CITY OF PORTLAND, MAINE
PLANNING BOARD

August 20, 2014

Project Name: Canal Landing/New Yard
Address: 100 West Commercial Street
Applicant: New Yard, LLC. – Canal Landing, LLC.
Project ID: #2014-123
CBL: 59-A-1
Planner: Rick Knowland, Senior Planner

DRAWN: CMW DATE: JUNE 2014
 DESIGNED: SRB SCALE: 1" = 50'
 CHECKED: SRB JOB NO.: 3091.03
 FILE NAME: 3091.03-FIRE PROTECTION
 SHEET: C-11.1

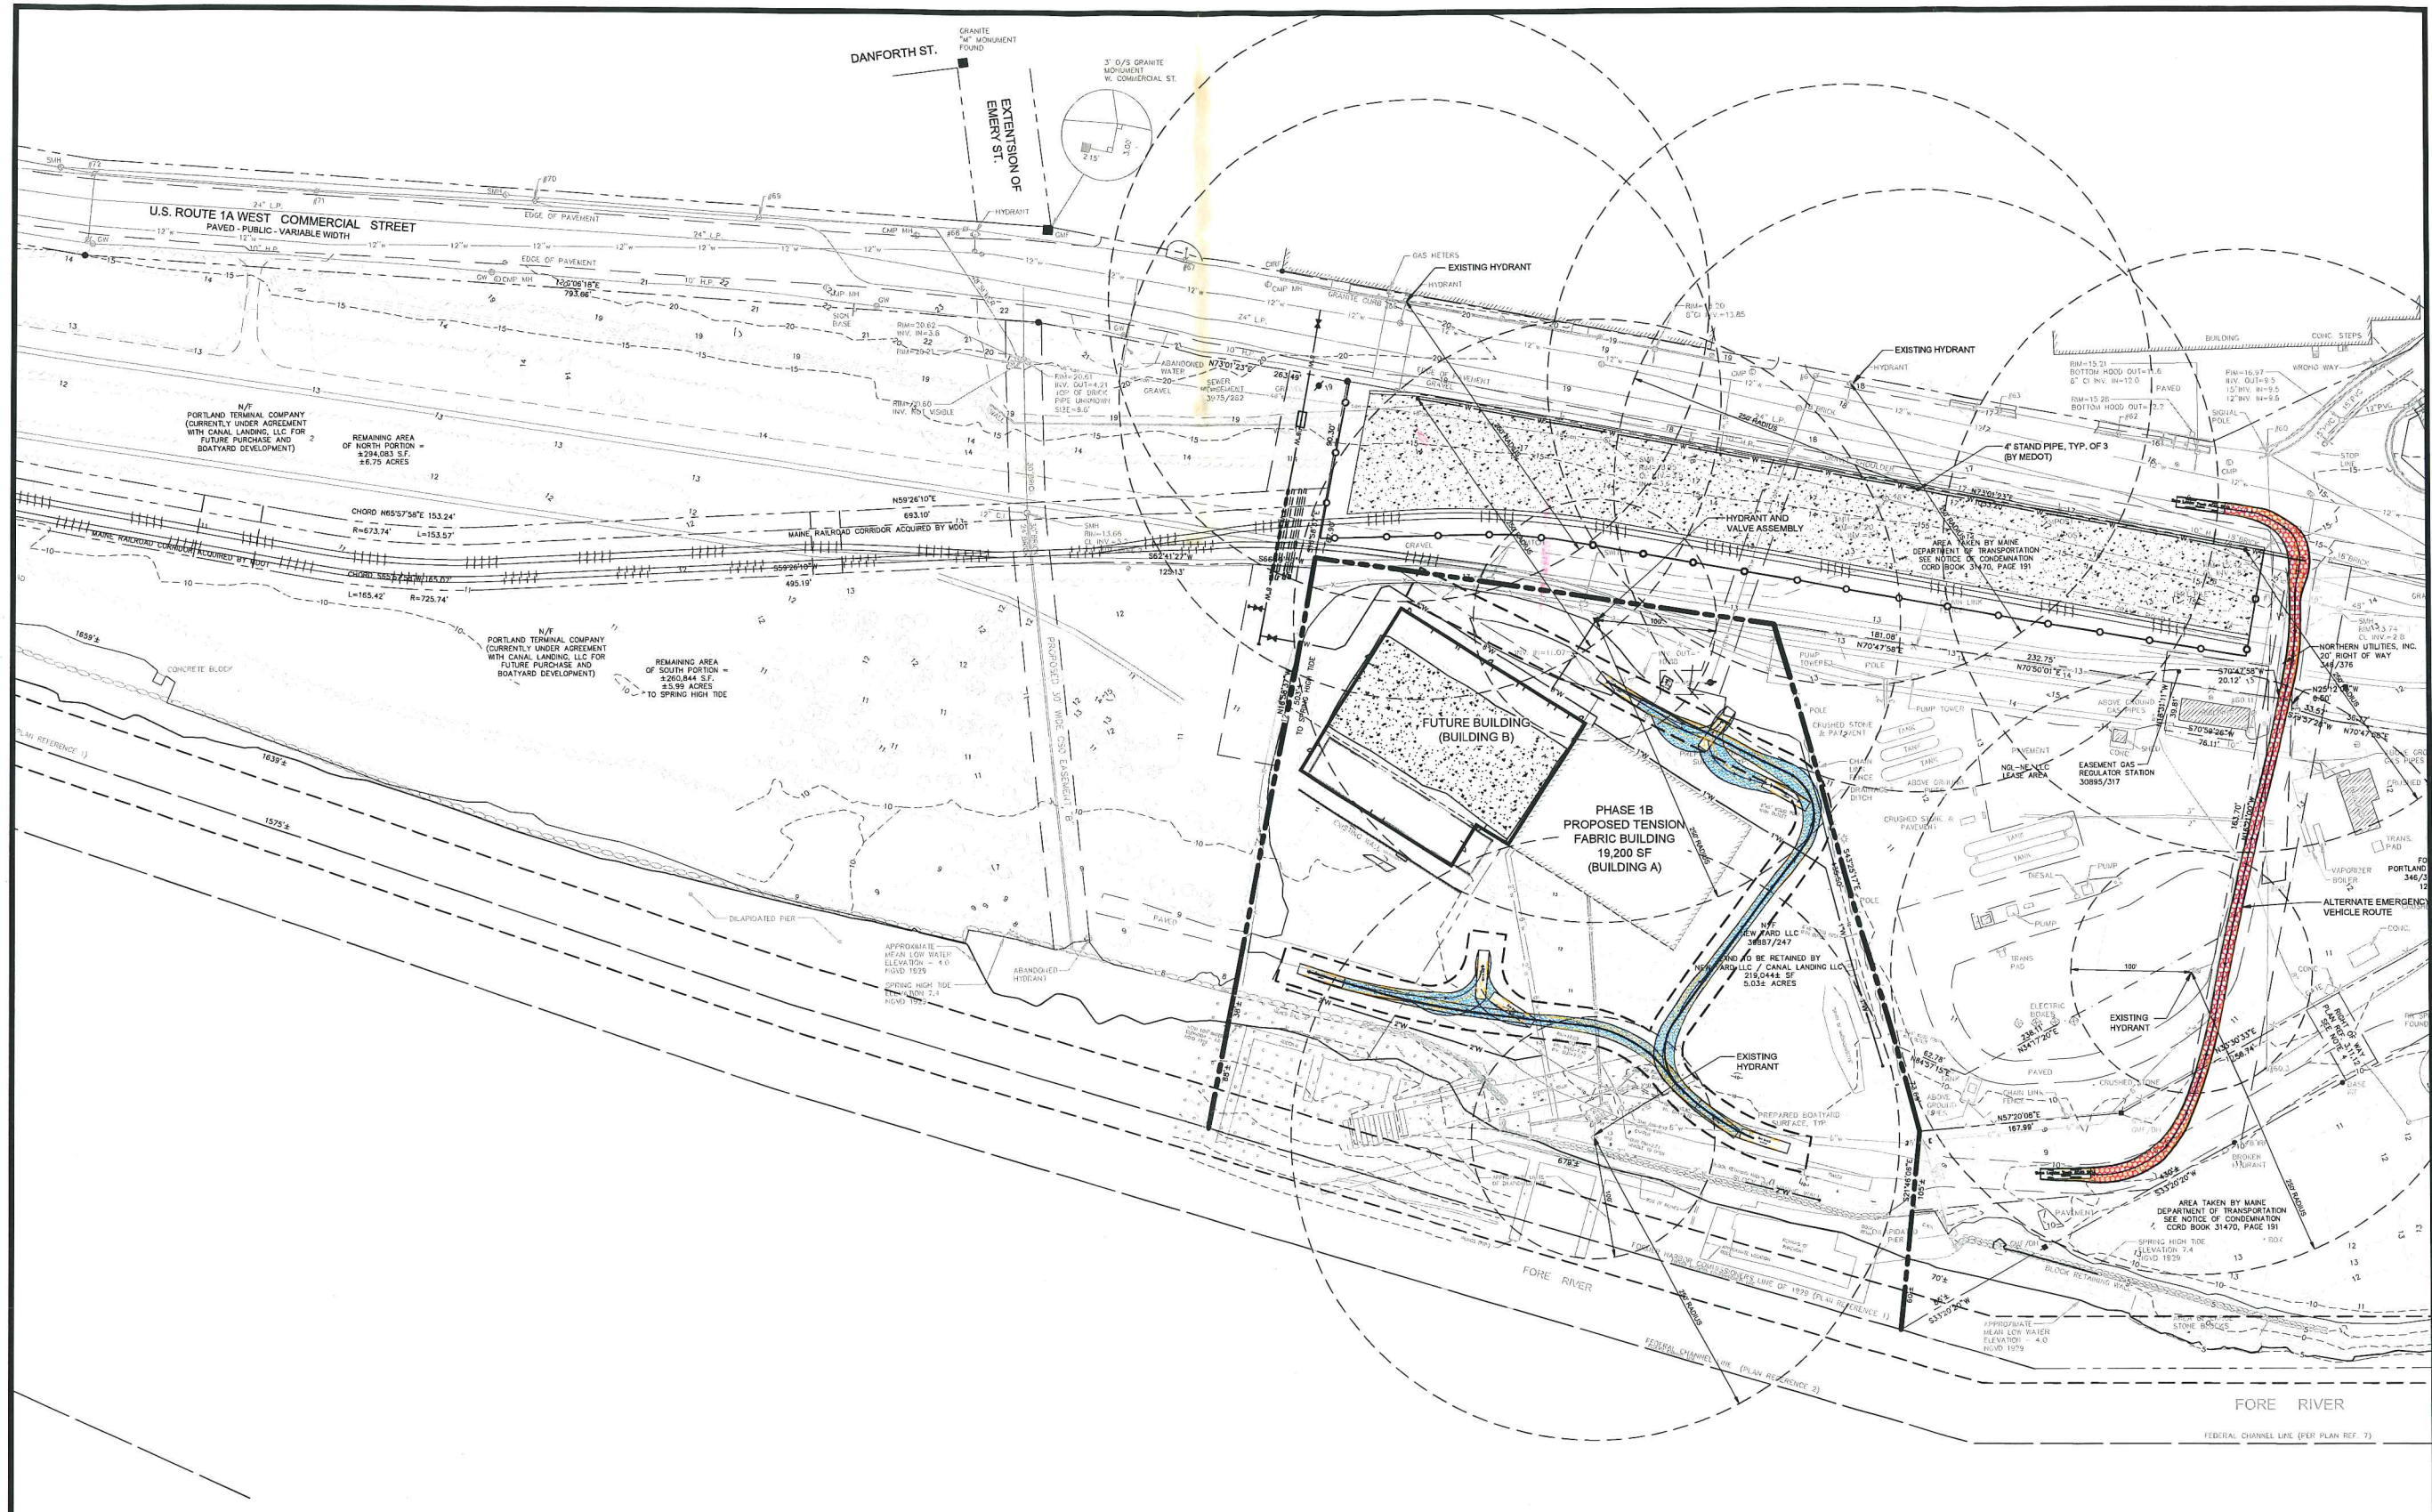
5. Prior to the issuance of a building permit the site plan shall be revised for review and approval by Chris Pirone (Fire Department) reflecting the 30 foot wide access around the site for Fire Department vehicles. Applicant shall also confirm the address of the property.
